From: Hannah Kersley
Sent: 28 October 2024 10:07
To: Planning.Responses
Subject: FW: 10 Cavendish Road - BR/180/24/PL
Attachments: 10 Cavendish Road - PG.9011.24.02 - Proposed Plans_Rev E.pdf

Please can this plan be uploaded to BR/180/24/PL – it will supersede the existing proposed plans.

I note the amendments last sent have not been uploaded to the website. Having read through the PSH comments again, we noticed there was concern about natural light to some rooms, so we have amended some windows to address this.

Drg. No. PG.9011 · 24 · 02 Rev. E

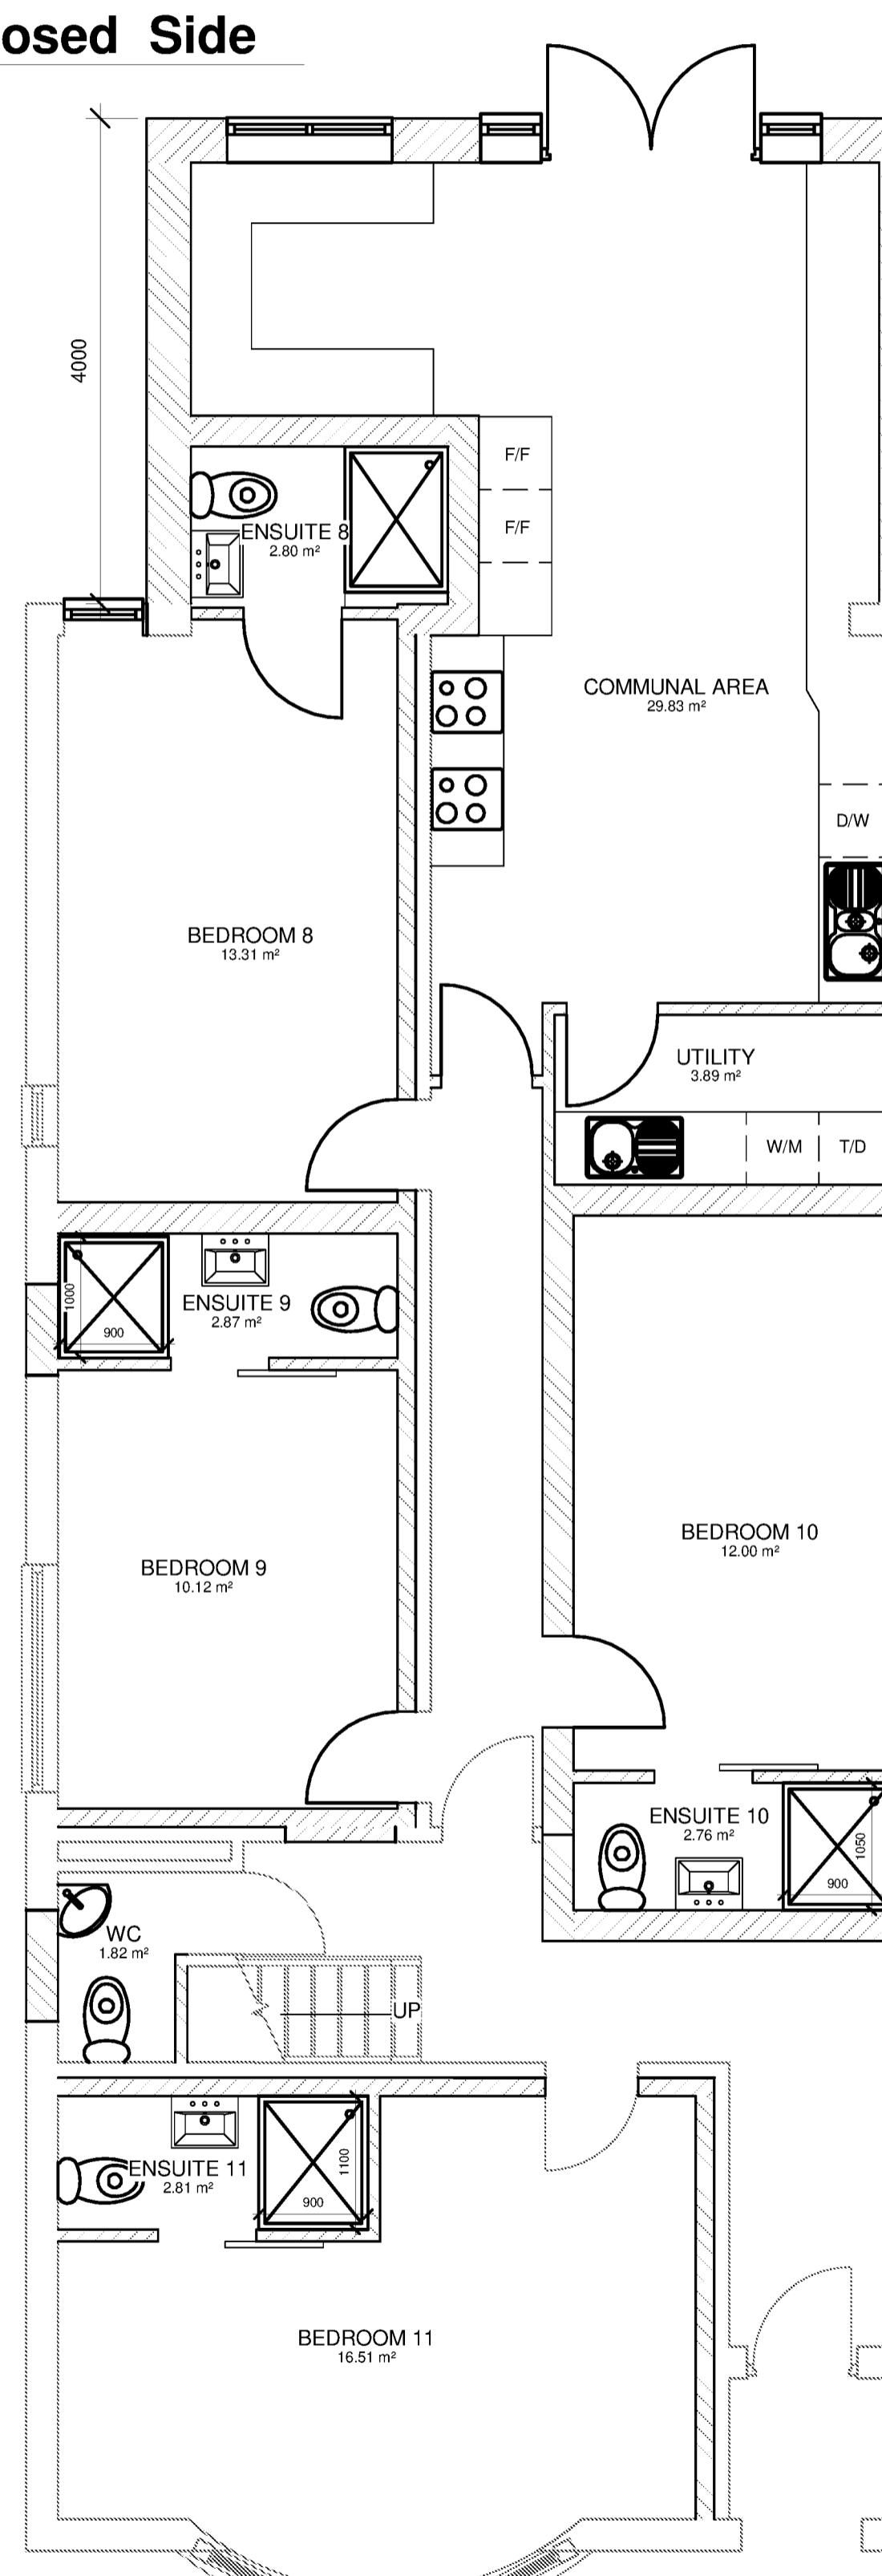
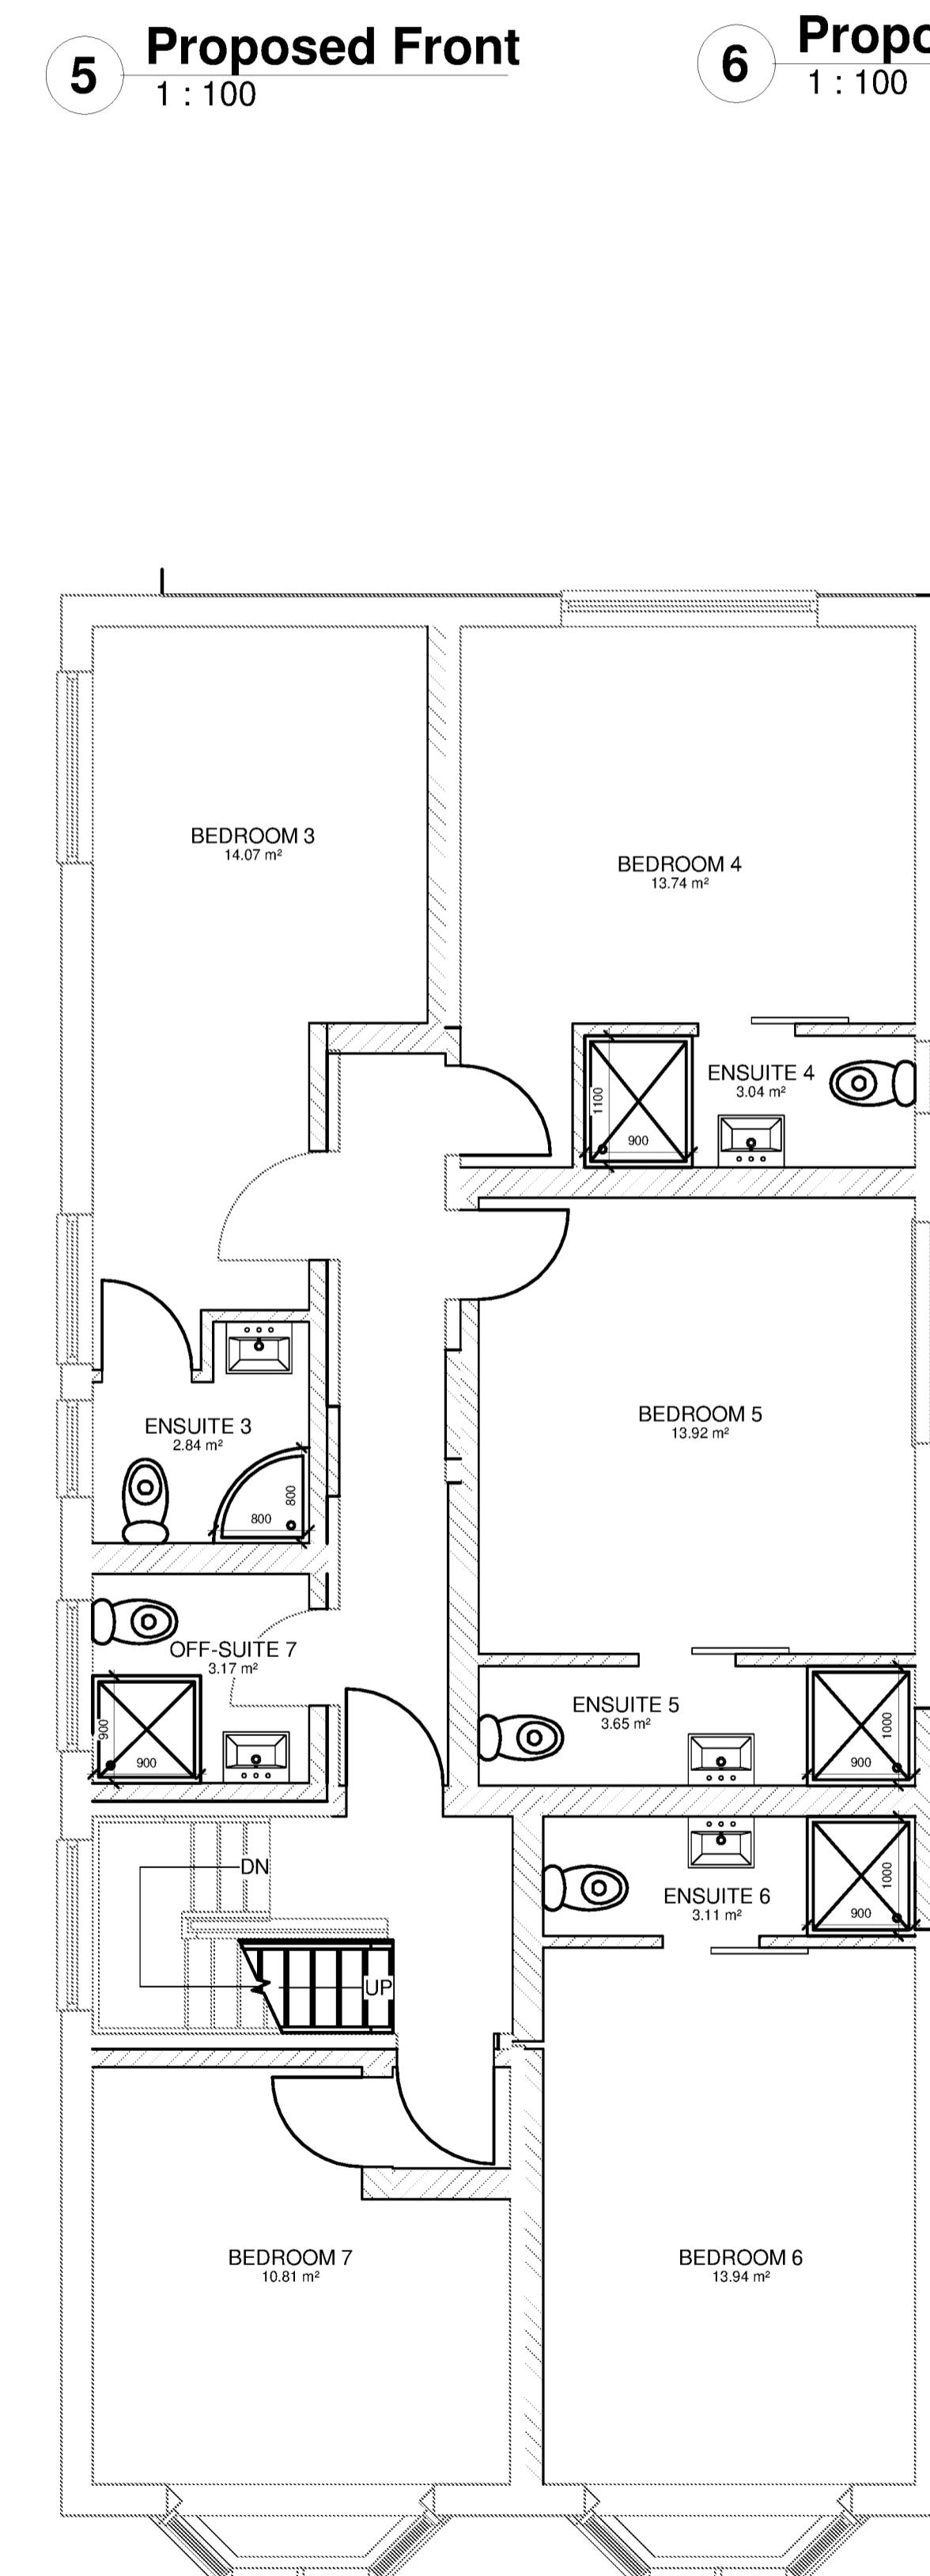
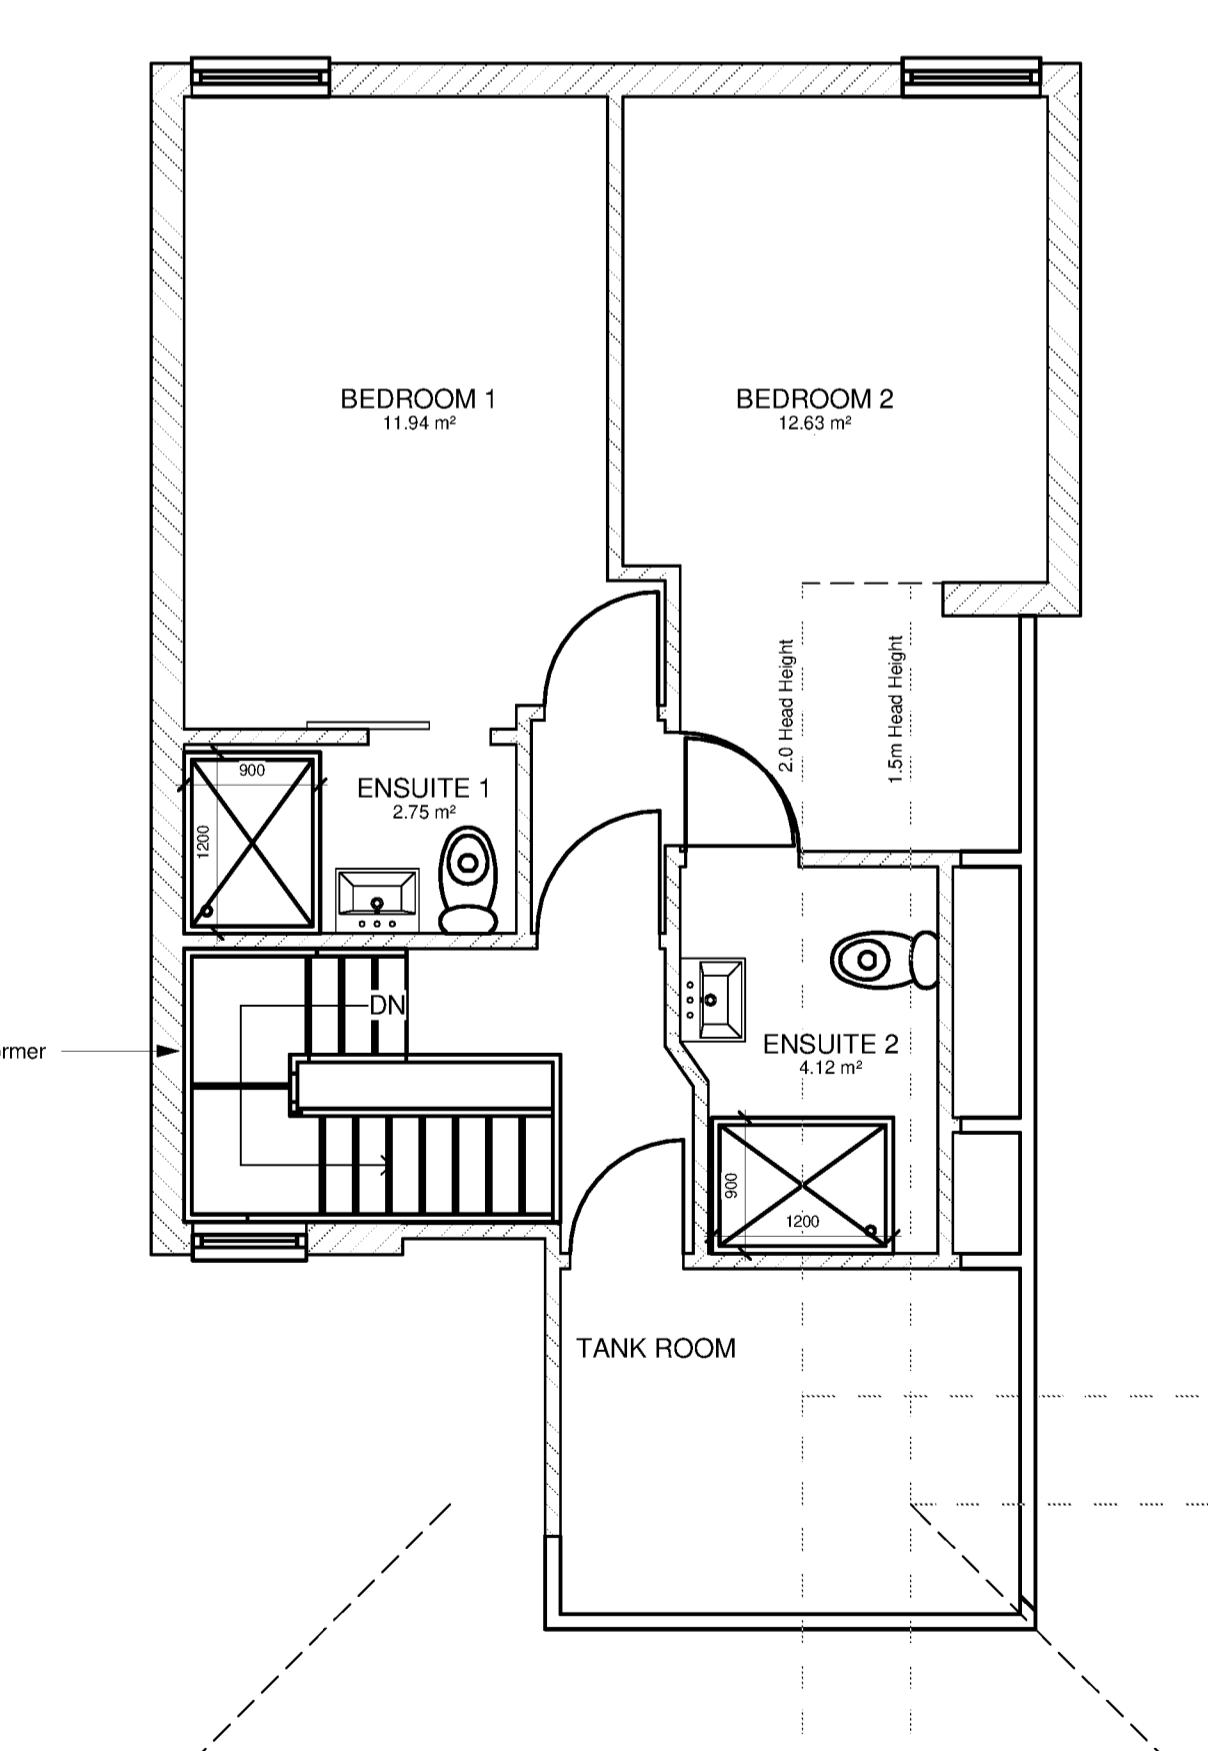
Apologies, my colleague has just added a further detail to the plan, to show the WC at ground floor.
